DRB Application No.: <u>03-01548</u>	Project # <u>1002964</u>
Project Name: <u>Richfield Park</u>	EPC Application No.: _____
Agent: <u>Shelley Heller Aretz</u>	Phone No.: <u>268-4144</u>

Re: Project #: 1002964
Application # 03DRB-01548

**CITY OF ALBUQUERQUE
PLANNING DEPARTMENT
Development Review Board
September 24, 2003 Comments**

RE: RICHFIELD PARK, LOT 21

① Site Plan
 Scale: 1"=20'-0"

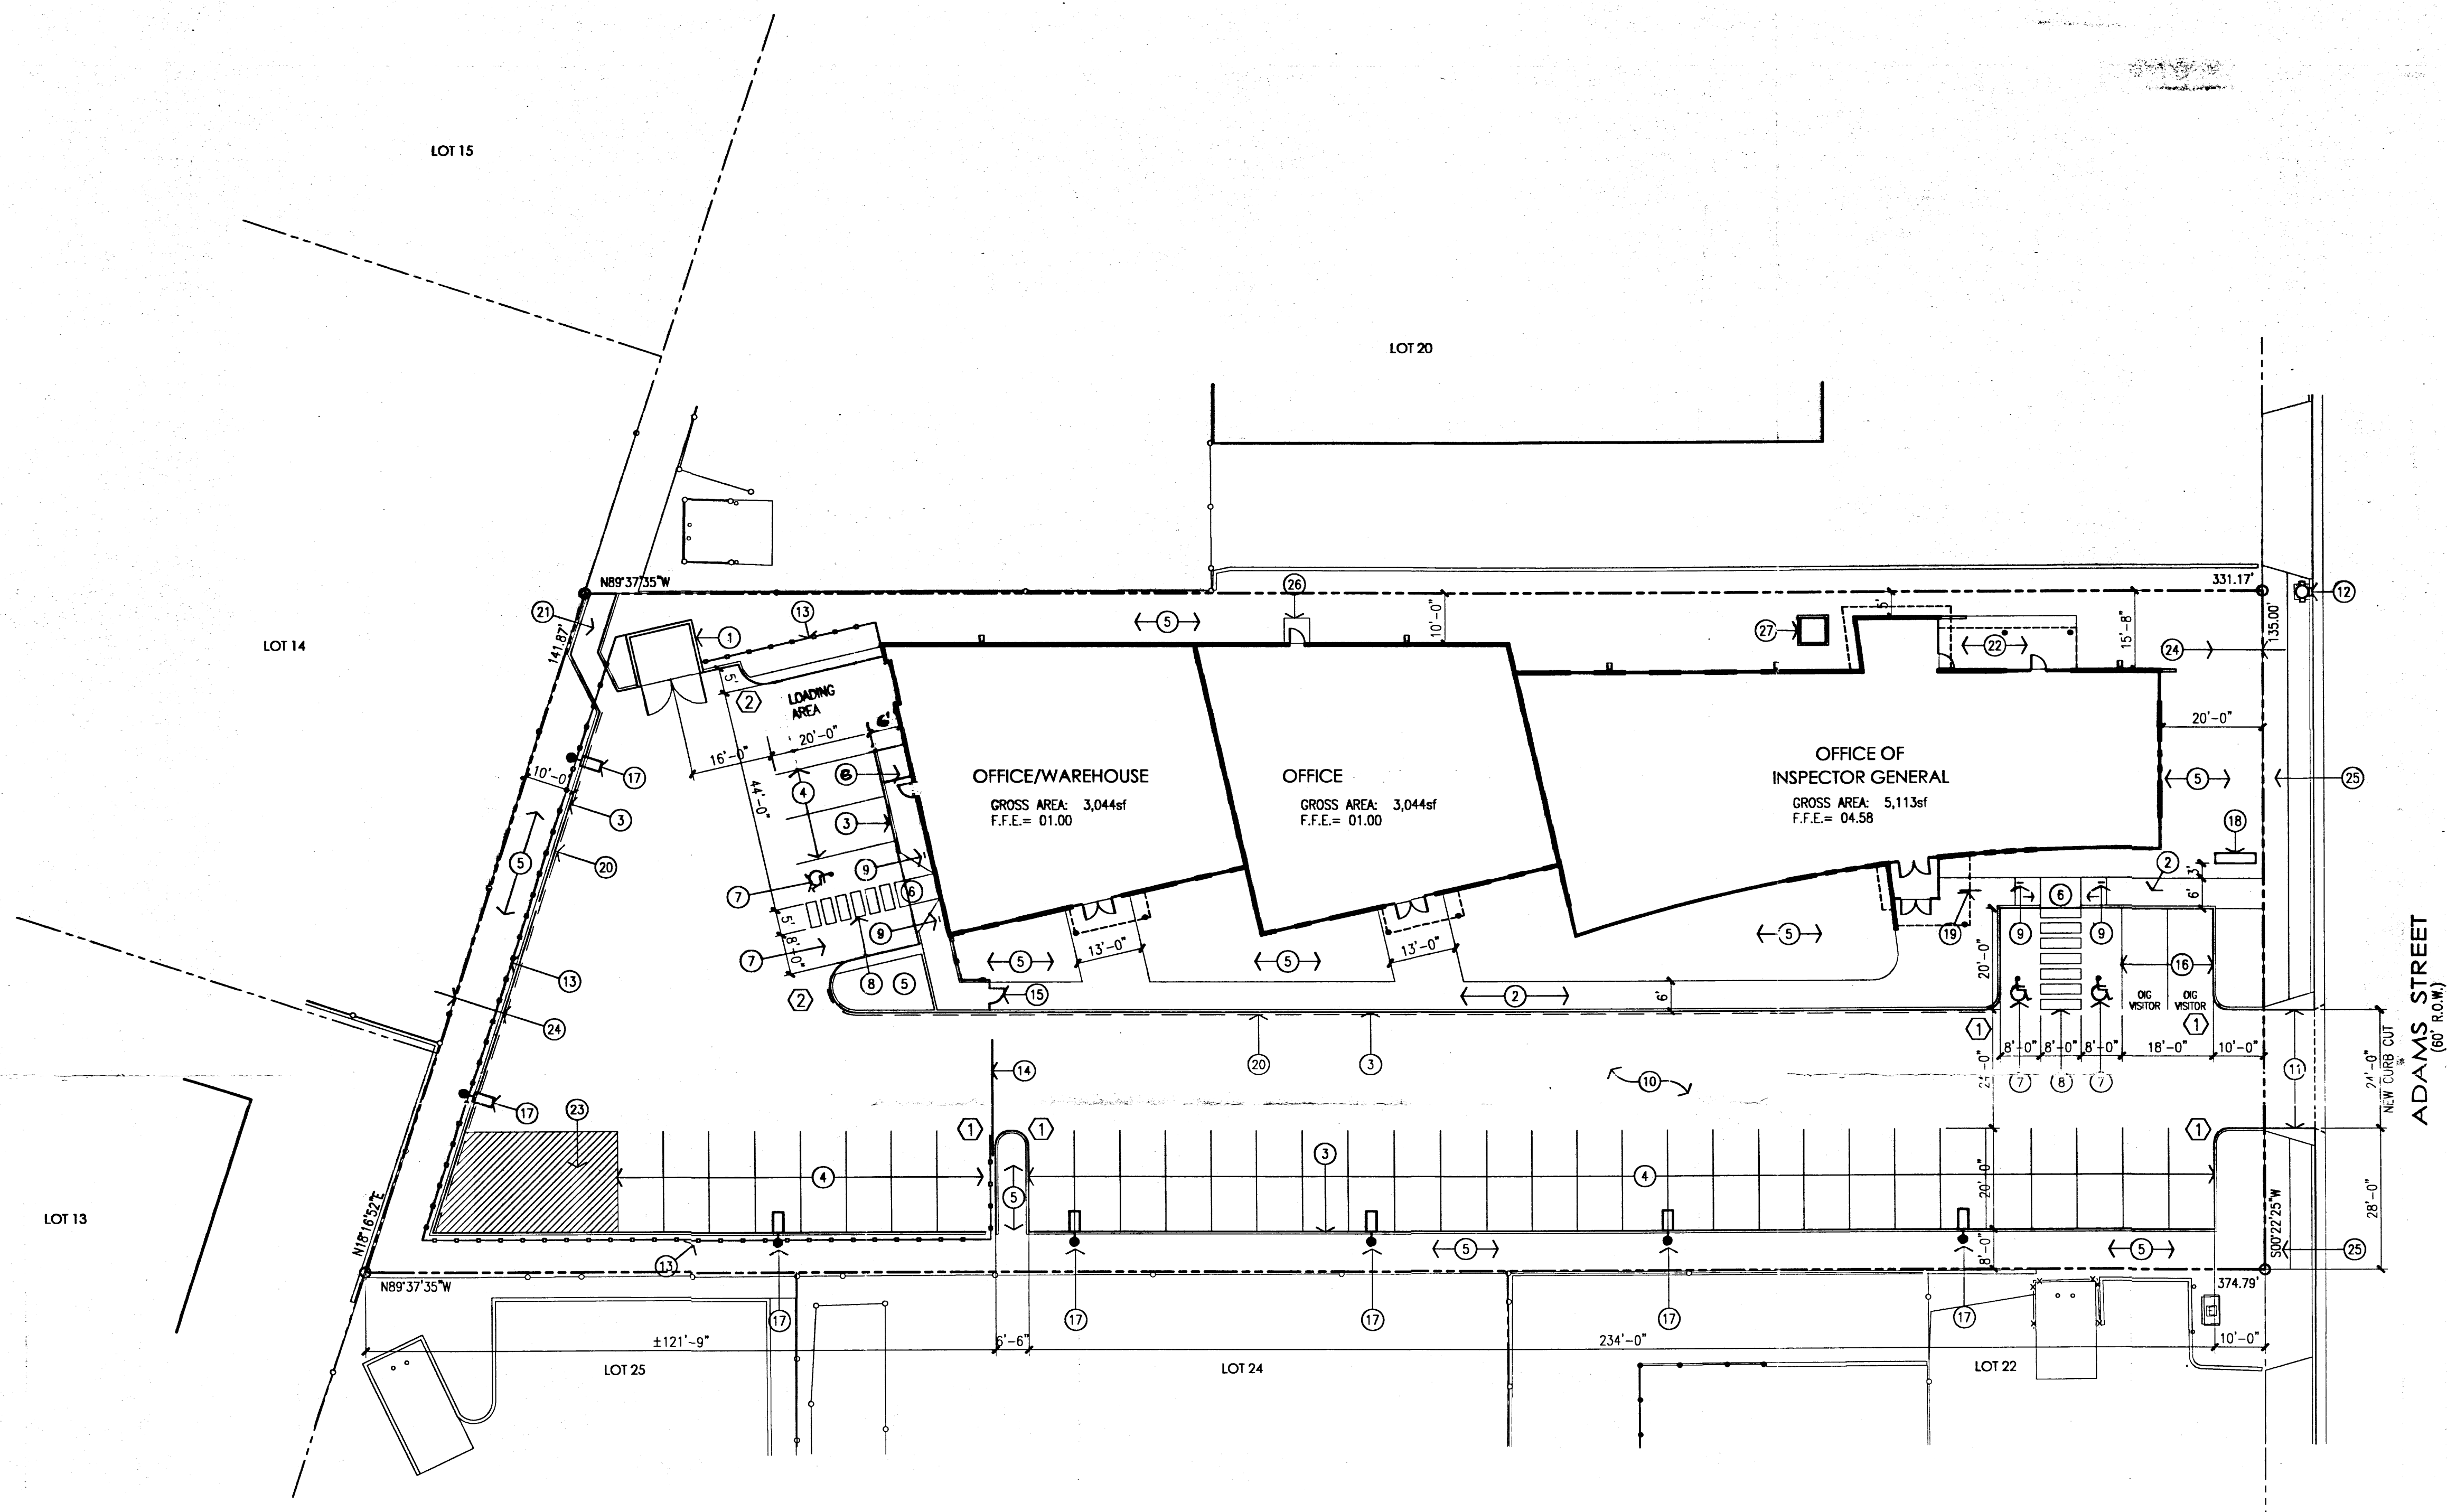
1. The site plan title should read "Site Development Plan for Building Permit". This clears up confusion when you apply for actual building permits.
- ✓ 2. On the buildings titled Lease Space 1 & 2, please indicate the proposed use, i.e., office, etc.

- ✓ 7. The North I25 Sector Plan requires that no parking space be more than 50 feet from a tree. There are spaces on the site plan as now shown that do not meet this requirement.

9. Text amendments passed last October to the Zoning Code require parking spaces to be 8.5' by 20' in size. Spaces over 20 in number may have one quarter of them at 8' by 15'.

- The site plan should be titled "Site Development Plan for Building Permit." *This has been changed on Sheet A001.*
- Clarify uses for two Office/Warehouse spaces and designate loading areas. *The use for the space adjacent to the west of the Office of Inspector General has been revised to be only an "Office" use. This has been noted on the plan and the parking calculations have been revised as such. The space on the west end of the building will remain "Office/Warehouse." A small surface loading area has also been designated for this space by removing two parking spaces, which is reflected in the overall parking calculations.*
